**City of Portland, Maine - Building or Use Permit**

<b>Permit No:</b> 06-0950	<b>Date Applied For:</b> 06/27/2006	<b>CBL:</b> 036 H003001
------------------------------	--	----------------------------

<b>Location of Construction:</b> 94 PORTLAND ST	<b>Owner Name:</b> SIMMONS JEAN C & ROBERT A	<b>Owner Address:</b> 39 MONA RD	<b>Phone:</b>
<b>Business Name:</b>	<b>Contractor Name:</b> Steve Carpentry Services	<b>Contractor Address:</b> 12 Deerfield Circle Standish	<b>Phone</b> (207) 310-8029
<b>Lessee/Buyer's Name</b>	<b>Phone:</b>	<b>Permit Type:</b> Change of Use - Commercial

<b>Proposed Use:</b> Commercial/ Residential- Interior repairs and upgrades to skylights, sheetrock electrical and plumbing add 1 dwelling unit on 4th flr	<b>Proposed Project Description:</b> Interior repairs and upgrades to skylights, sheetrock electrical and plumbing add 1 dwelling unit on 4th flr
---	--

94 Portland -  
36-H-3

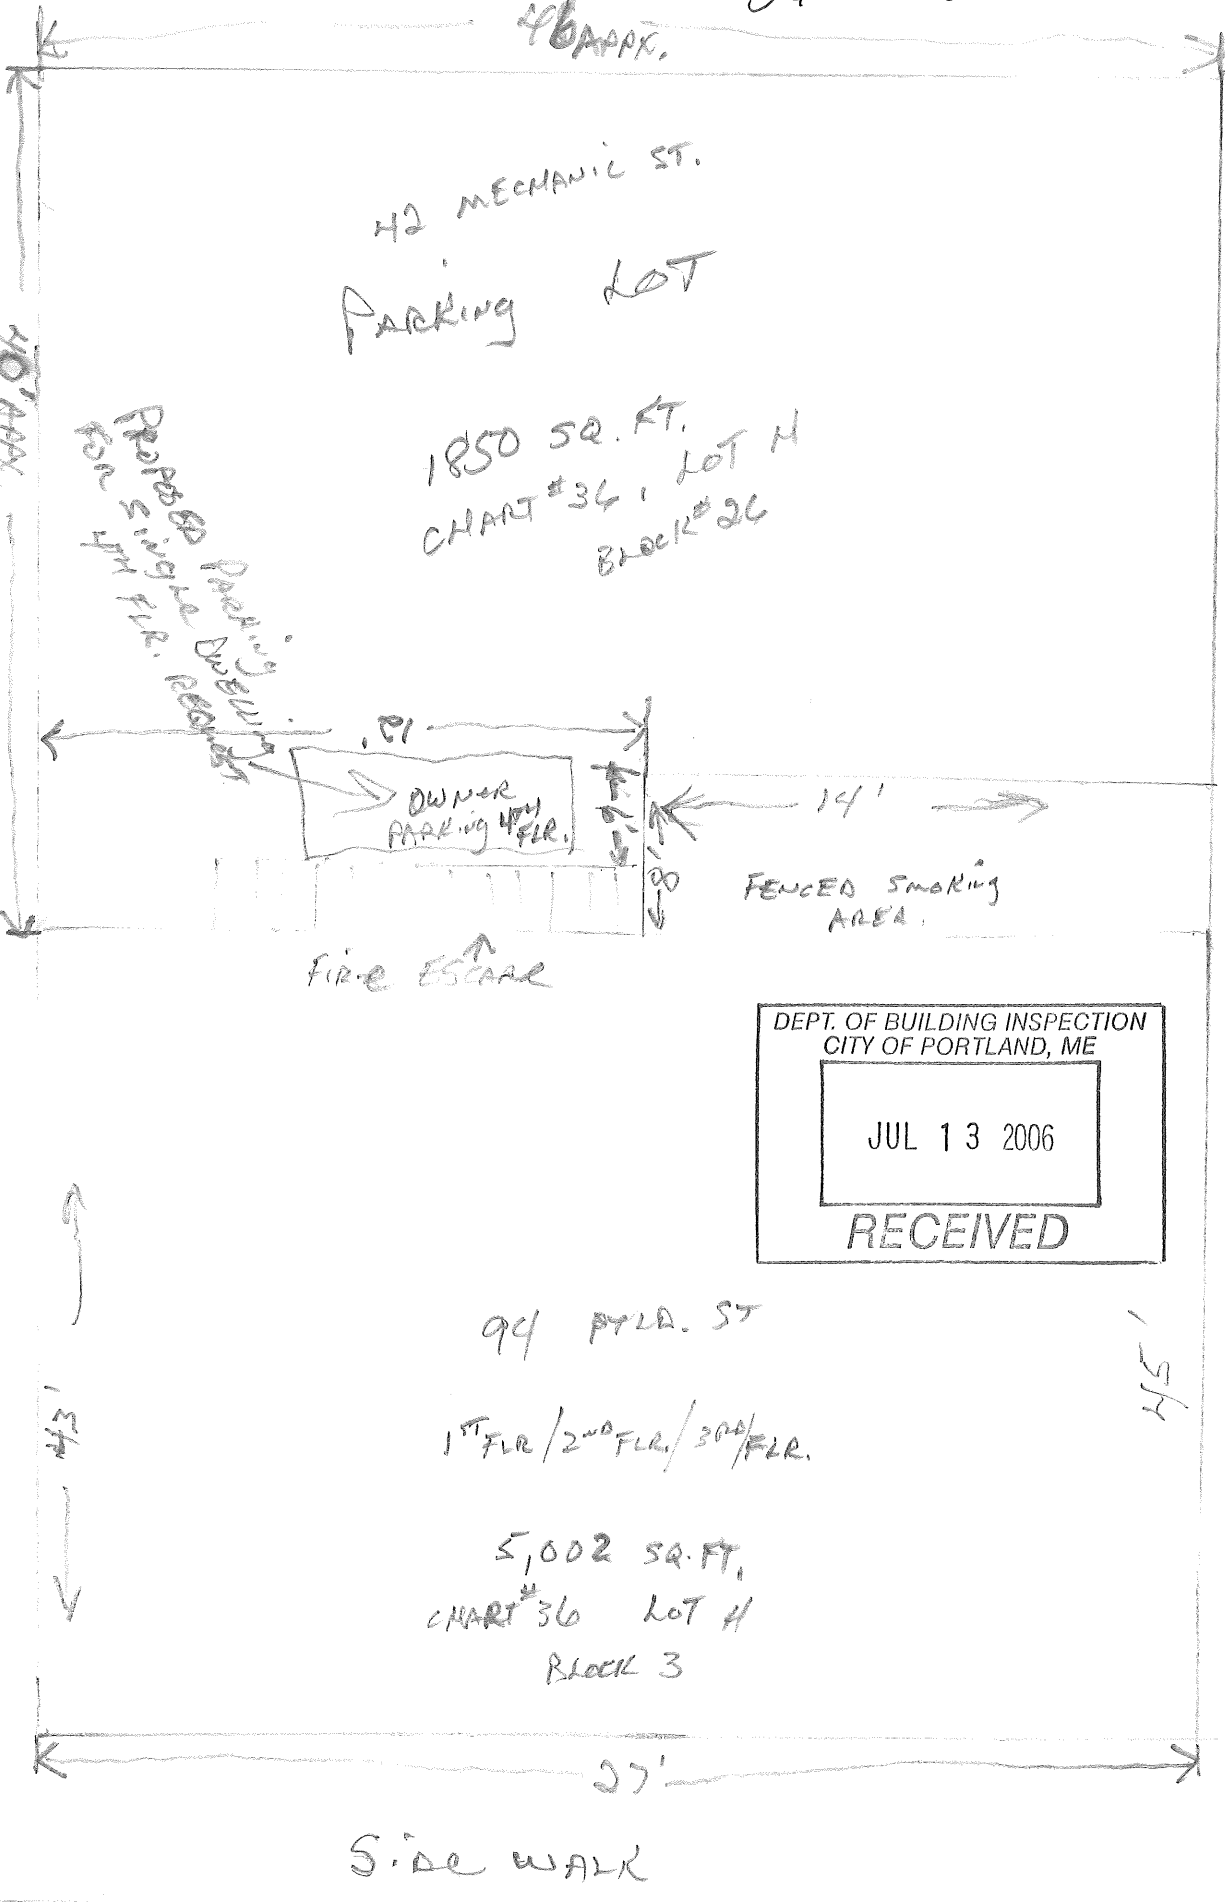
1 parking space - need plat plan

Fourth floor - new unit 45' +/-

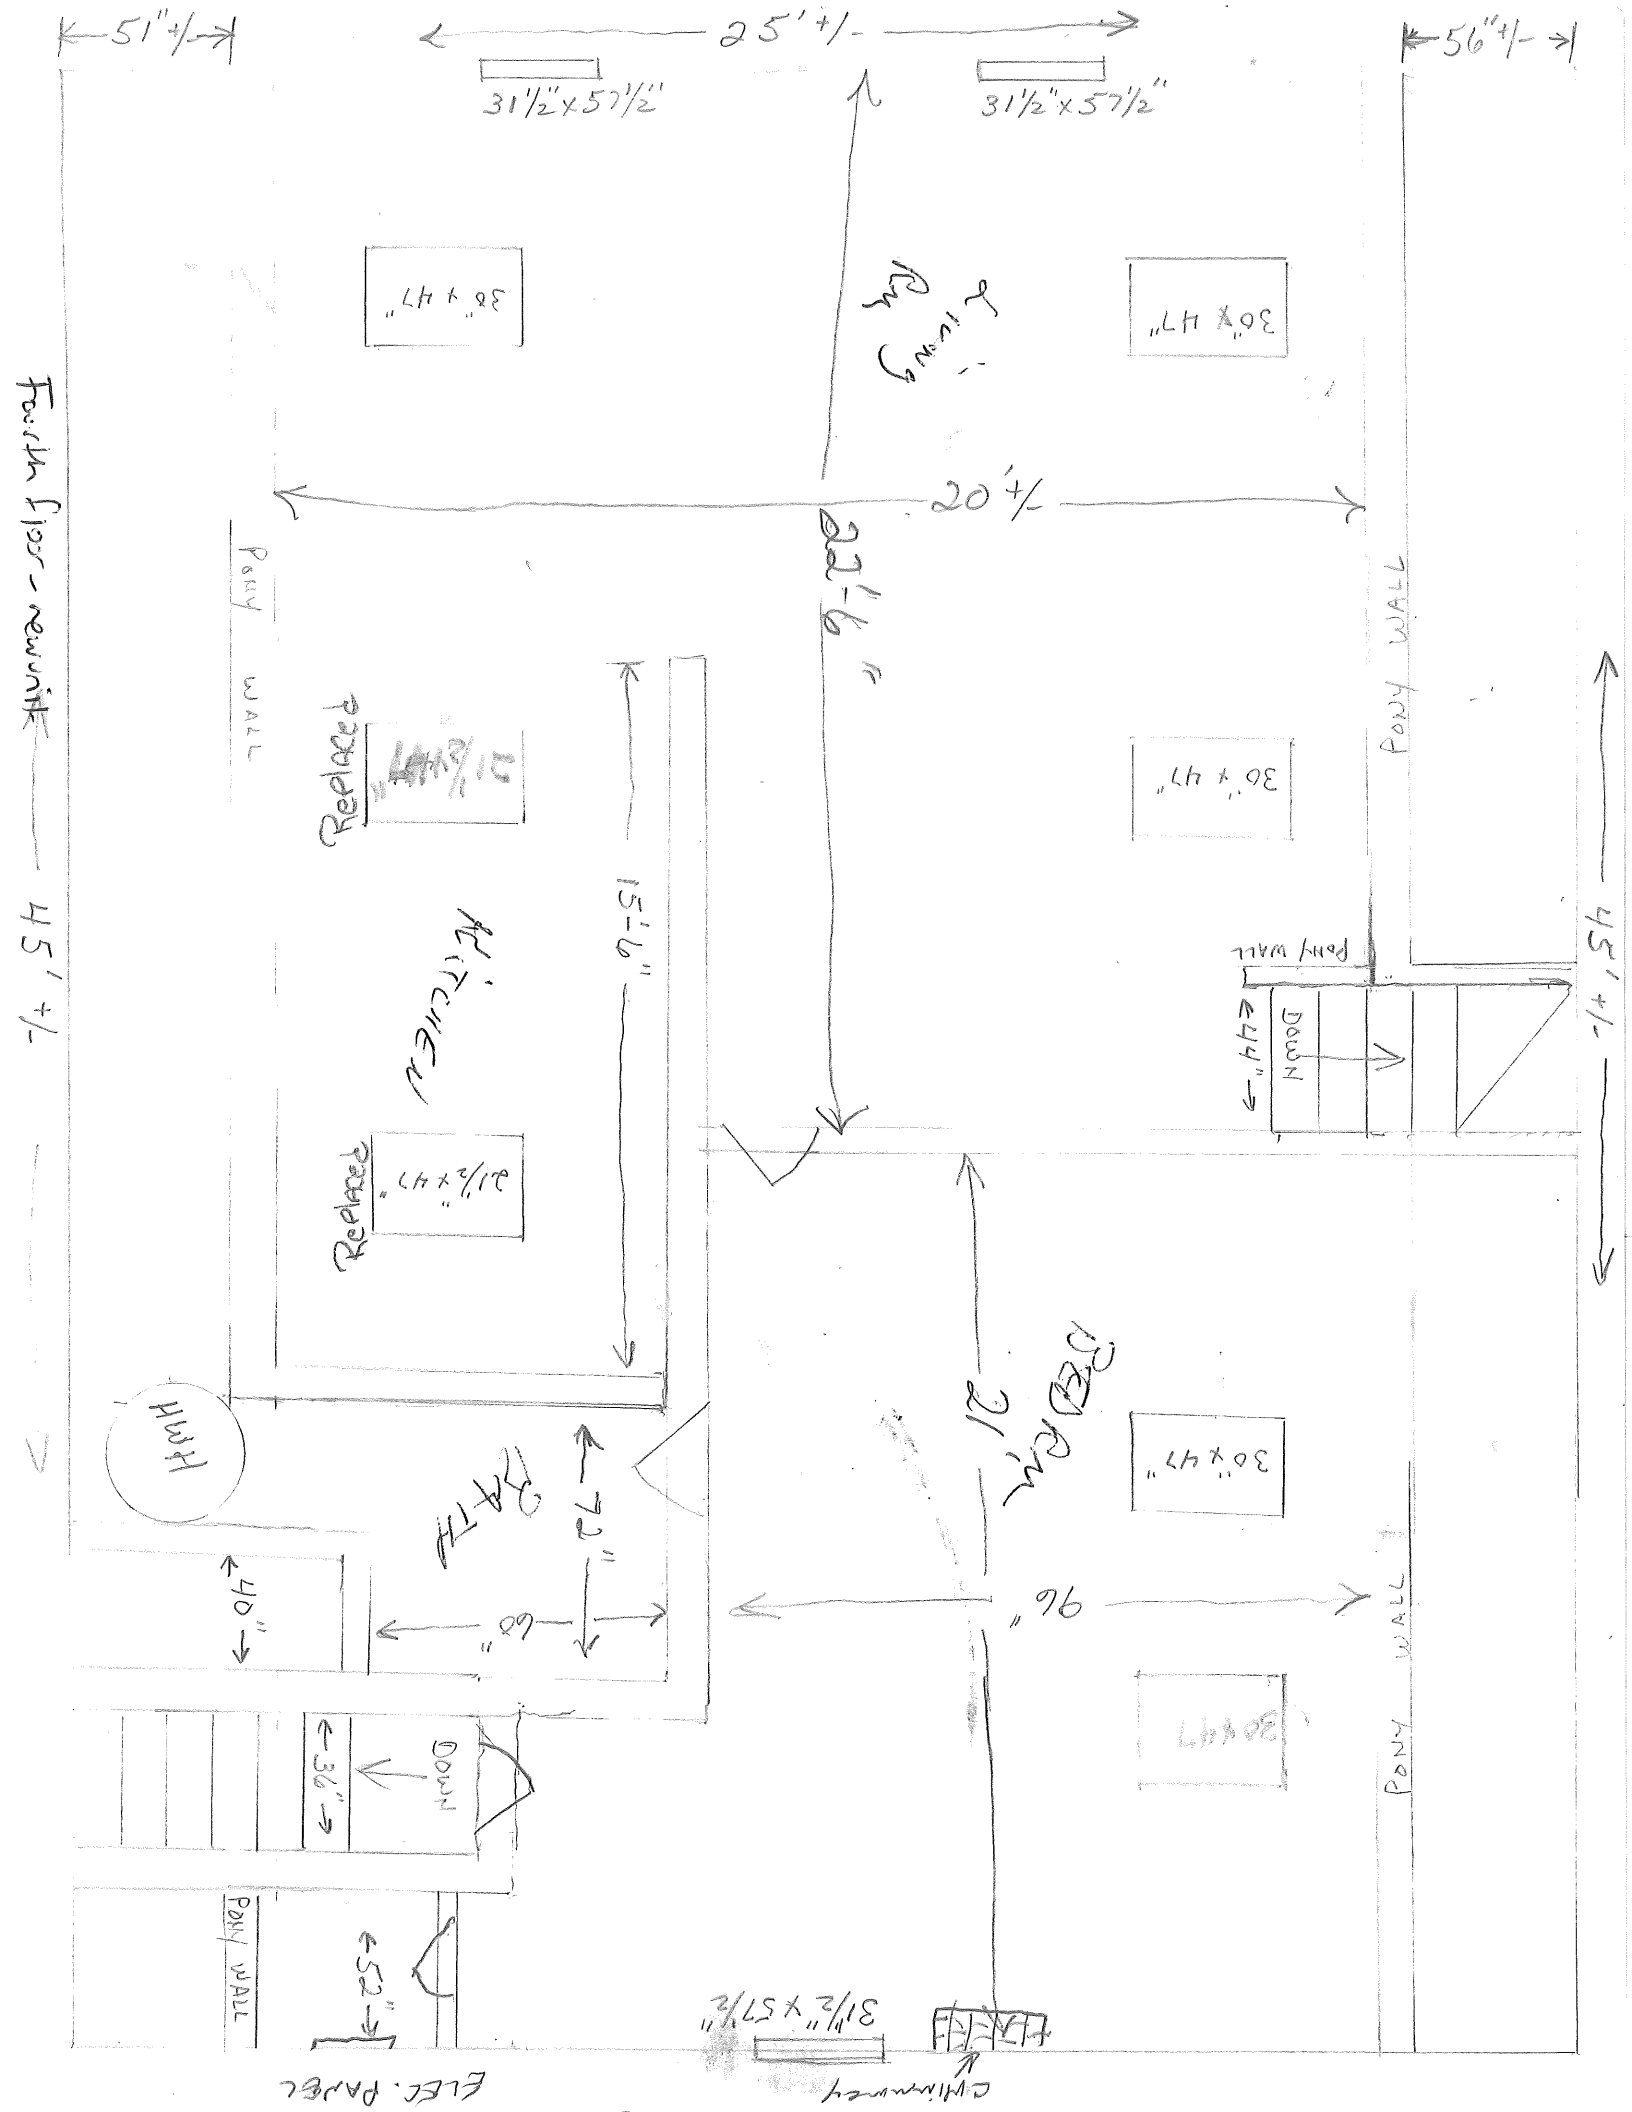
- 1) Egress windows must be installed in each sleeping room.
- 2) PLEASE REVIEW THESE CONDITIONS \*\*\*\*\*The proposal is to finish an existing attic for a fourth floor apartment. Because the building is Type 3B construction. The new unit must be retrofitted with a fire suppression system that complies with NFPA 13. Plans for this work must be submitted for approval prior to commencement of construction.
- 3) A copy of the executed contract for this work must be submitted prior to commencement of construction.
- 4) The unit must be separated from the common halls and the floor below by materials having a one hour fire resistance rating w/ a sound transmission class of 50 and all openings protected in accordance with Chapter 7 of the 2003 IBC.

- 1) All new apartments are required to be protected with a suppression system
- 2) All building construction shall comply with NFPA 101  
Two means of egress required each unit and to be separated w/ 1 hr rated construction.

This is for an additional dwelling in the attic on the fourth floor, I visited there today and according to the "simonds" ruling, I think it could trigger fire suppression, also, based on the conditions of approval, it needs a change of use, I'll send it back to zoning.

Floor plans of attic space - how set up
